**KIRKLEES METROPOLITAN COUNCIL
INVESTMENT & REGENERATION SERVICE**

**DELEGATED DECISION TO DETERMINE APPLICATIONS FOR
CONSENT, AGREEMENT OR APPROVAL REQUIRED BY CONDITION**

Reference No:	2026/44/90555/W
Site Address:	Land off, Woodhead Road, Brockholes, Holmfirth
Description:	Discharge of details reserved by conditions 13 (retaining walls), 15 (retaining walls (materials)), and 17 (surface water features in the Highway) on previous permission 2021/92206 for erection of 137 homes with open space, landscaping and associated infrastructure
Recommending Officer:	Louise Bearcroft

DECISION – Discharge of Condition – Issue Split Decision

TITLE
SECTION 104 LAYOUT SHEET 2 OF 2

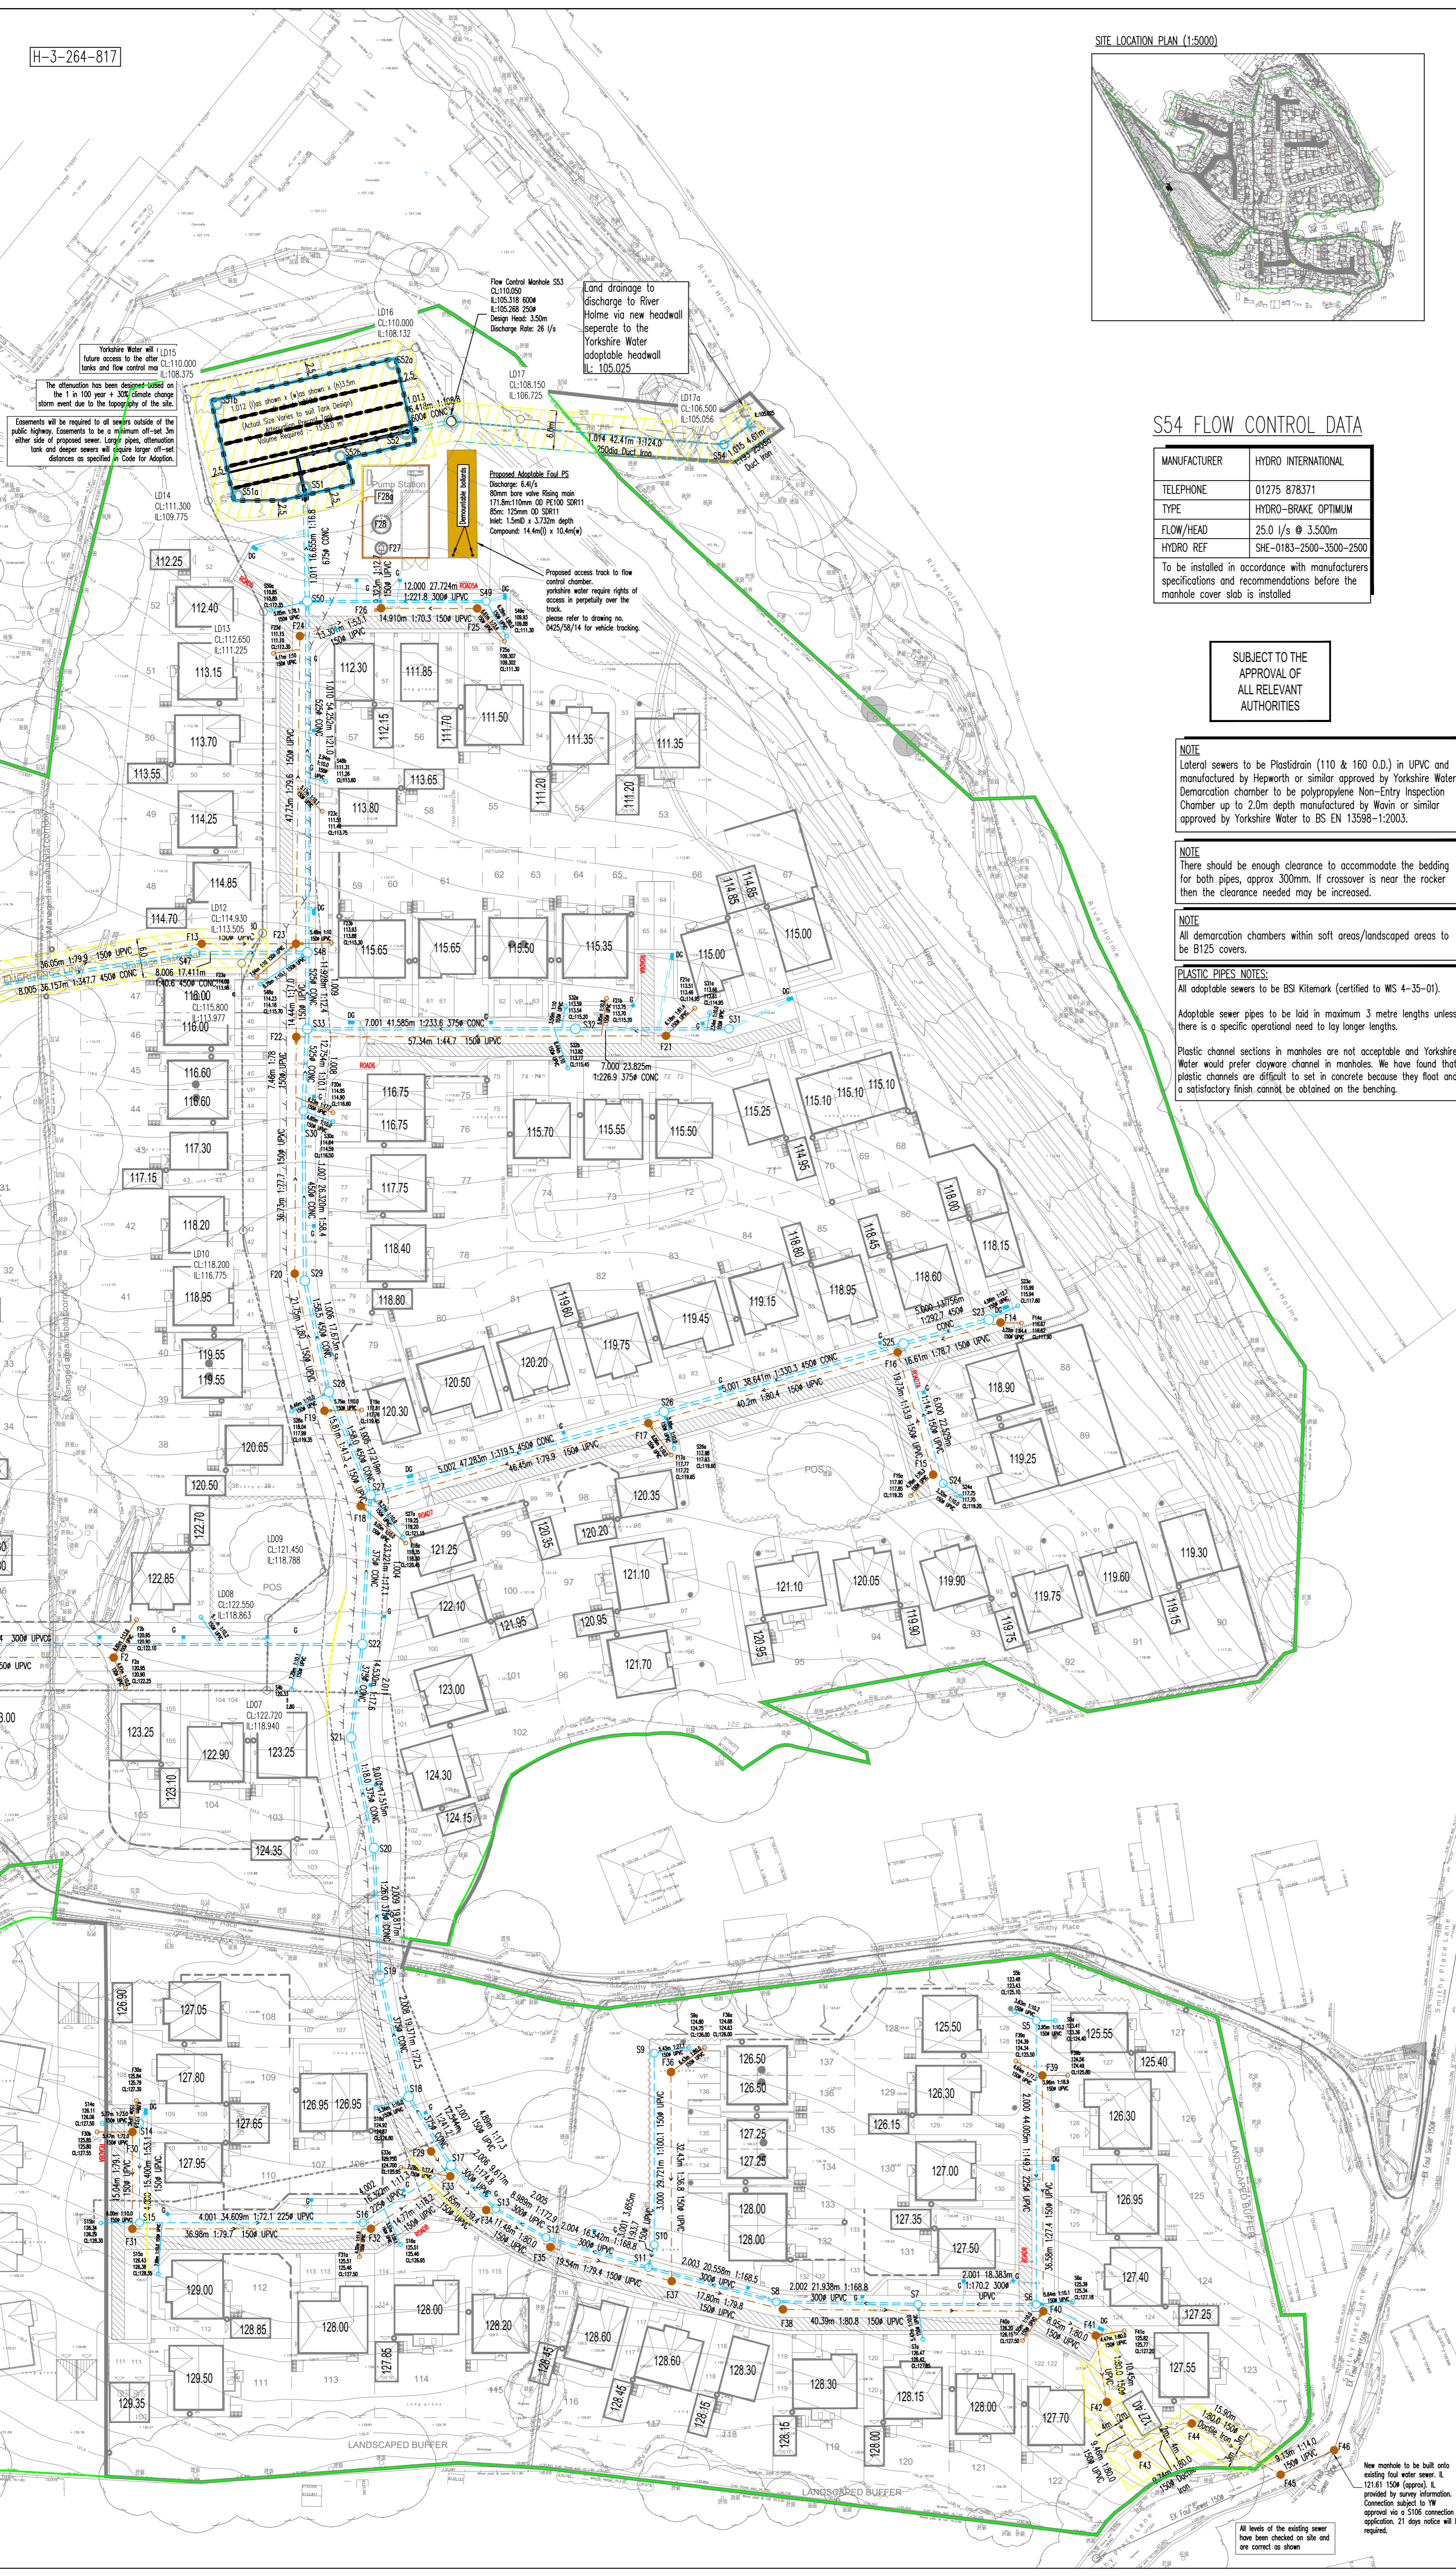
This condition cannot be discharged pending the satisfactory certification of oversize manholes (classed as structures) located in the highway.

In accordance with the comments from K.C Highways Structures, the details are not considered satisfactory for the purposes of satisfying Condition 17 at this time. This is due to a need for the satisfactory certification of oversize manholes (classed as structures) located in the highway. It is not recommended that the submitted details be approved at this time.

K.C Highways Structures require satisfactory certification of oversize manholes (classed as structures) located in the highway. This has not been provided. Therefore, the details submitted are not considered satisfactory for the purposes of satisfying Condition 17.
